**From:** Zac Denton  
**Sent:** 08 August 2019 16:12  
**To:** Planning.Responses <Planning.Responses@arun.gov.uk>  
**Subject:** FW: M/45/19/DOC

**From:** Laura Gibbons  
**Sent:** 16 July 2019 12:12  
**To:** Zac Denton <[Zac.Denton@arun.gov.uk](mailto:Zac.Denton@arun.gov.uk)>  
**Subject:** M/45/19/DOC

Engineers Comments Regarding Condition 5- Surface Water Drainage

No. 93/16/05 X

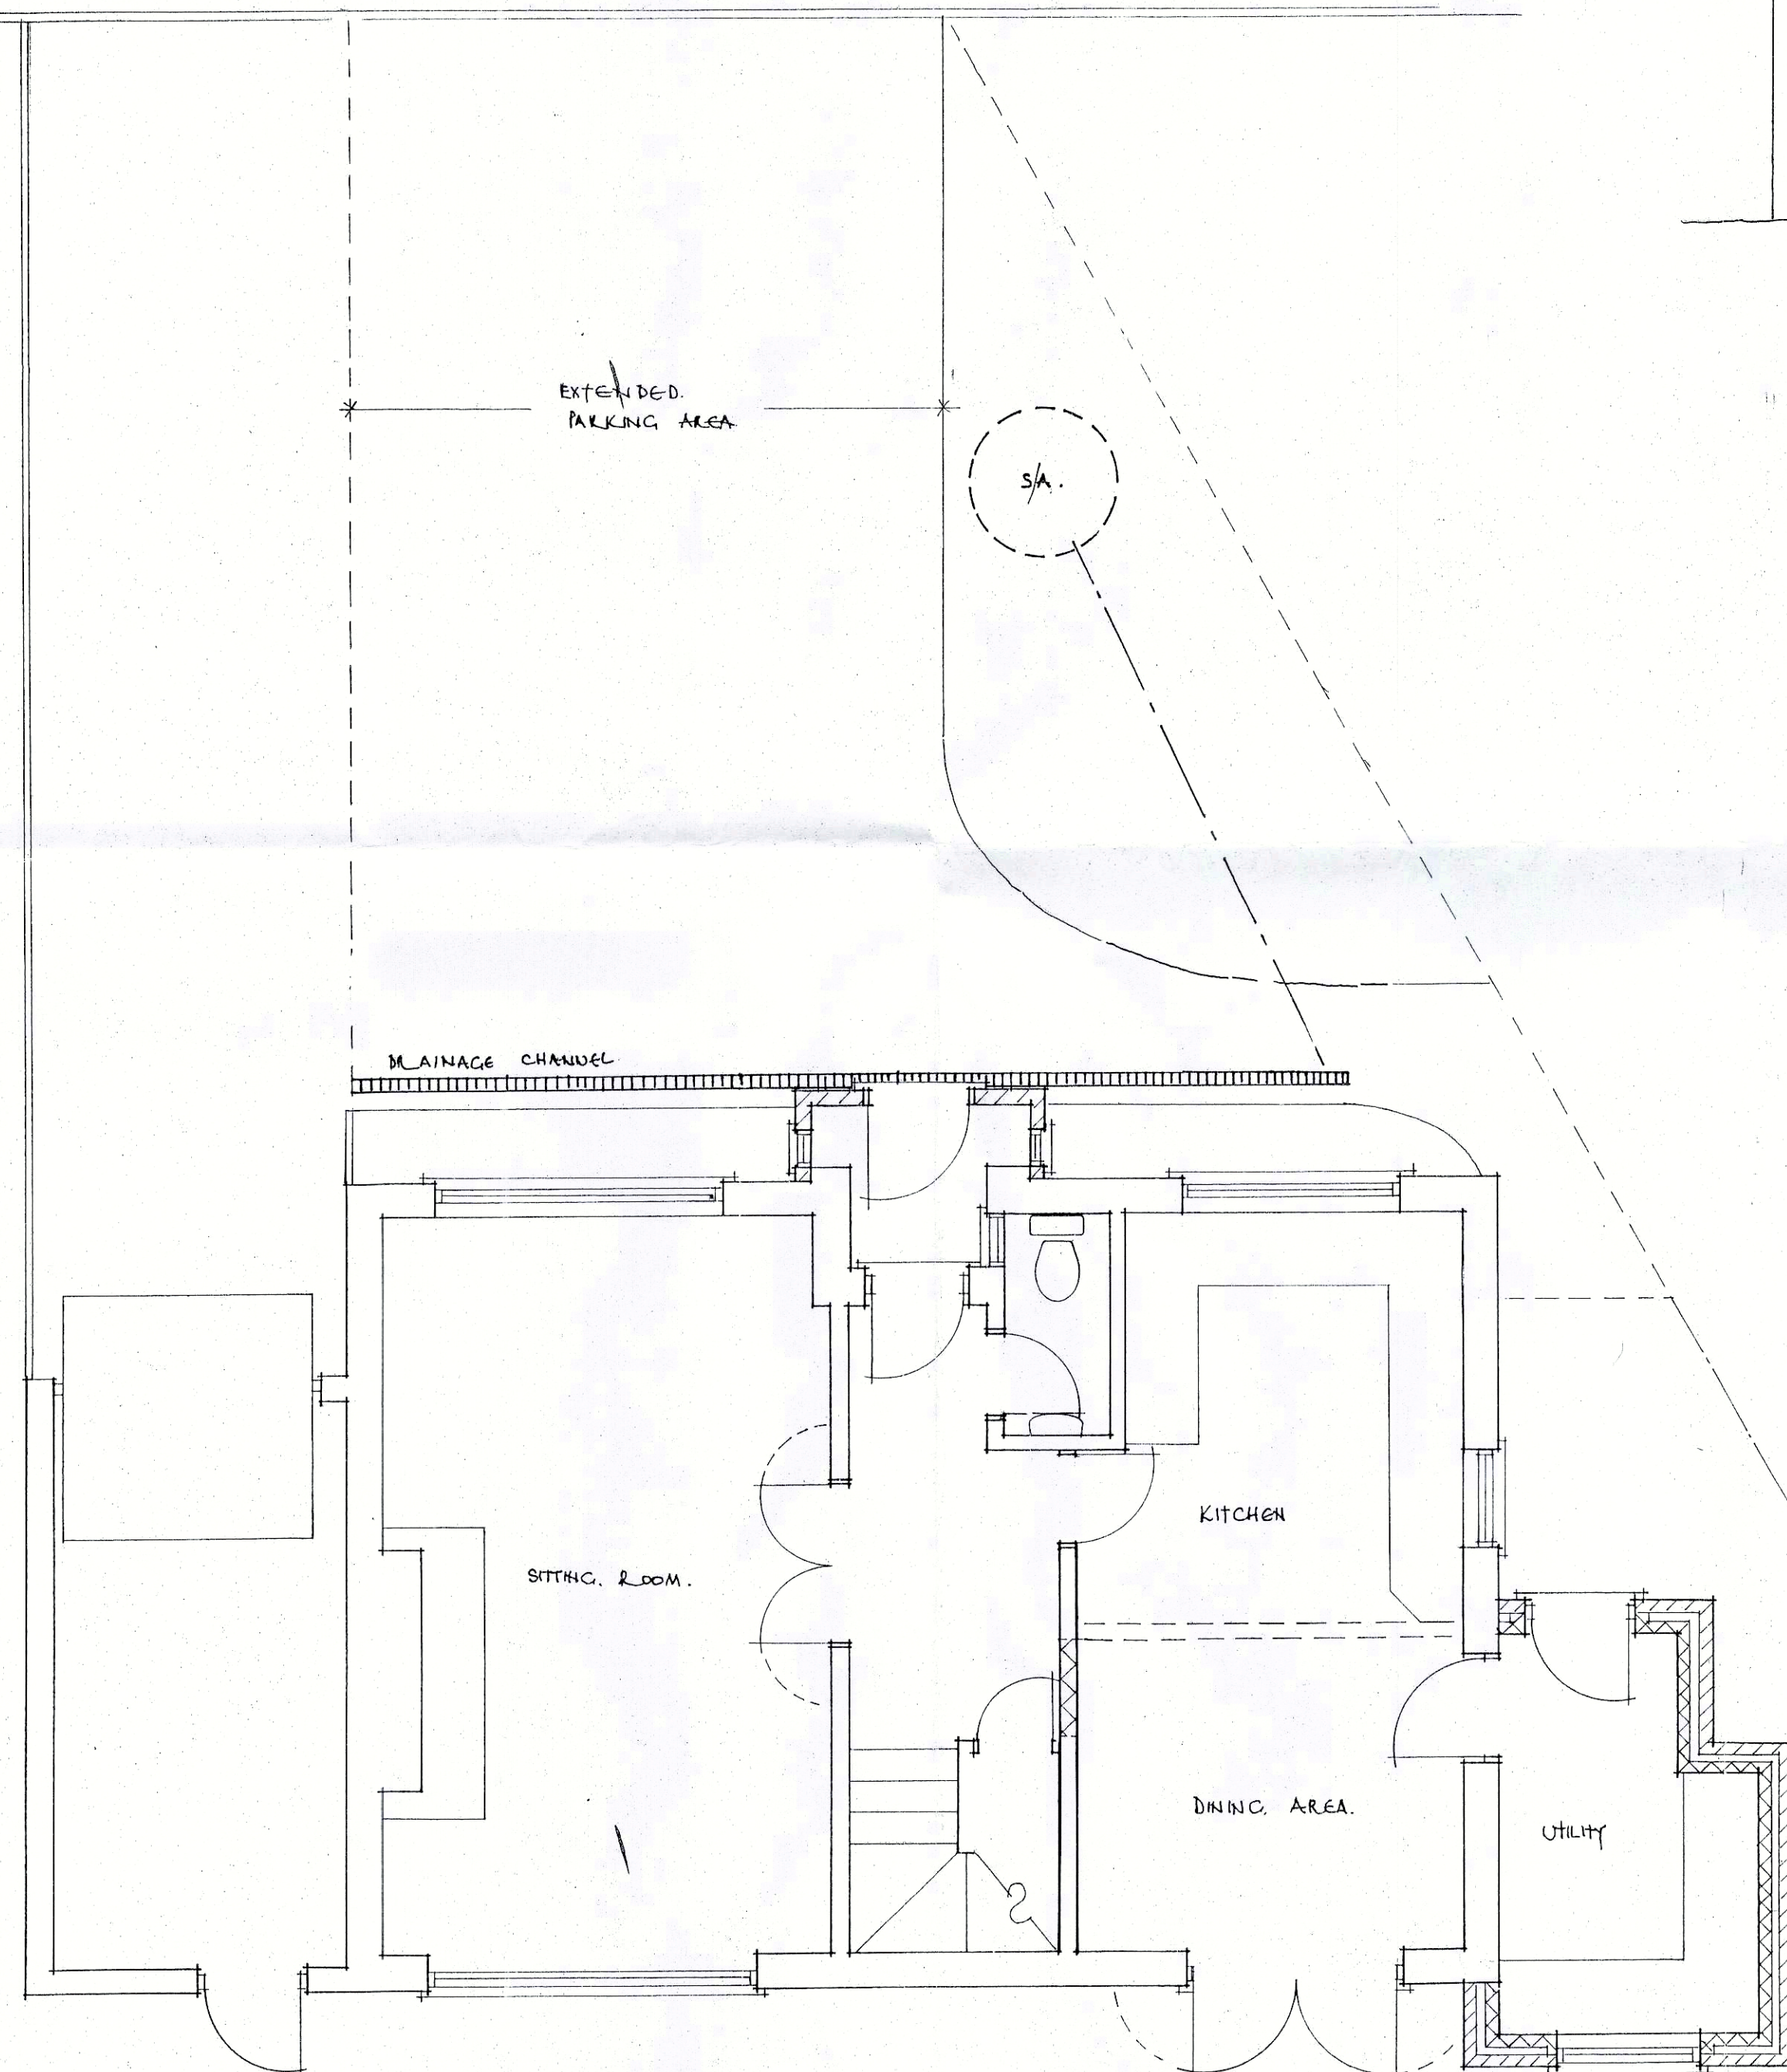
No groundwater monitoring, infiltration testing, calculations or details have been submitted.

Please can the applicant complete our drainage checklist (attached) and submit this with the supply of further information.
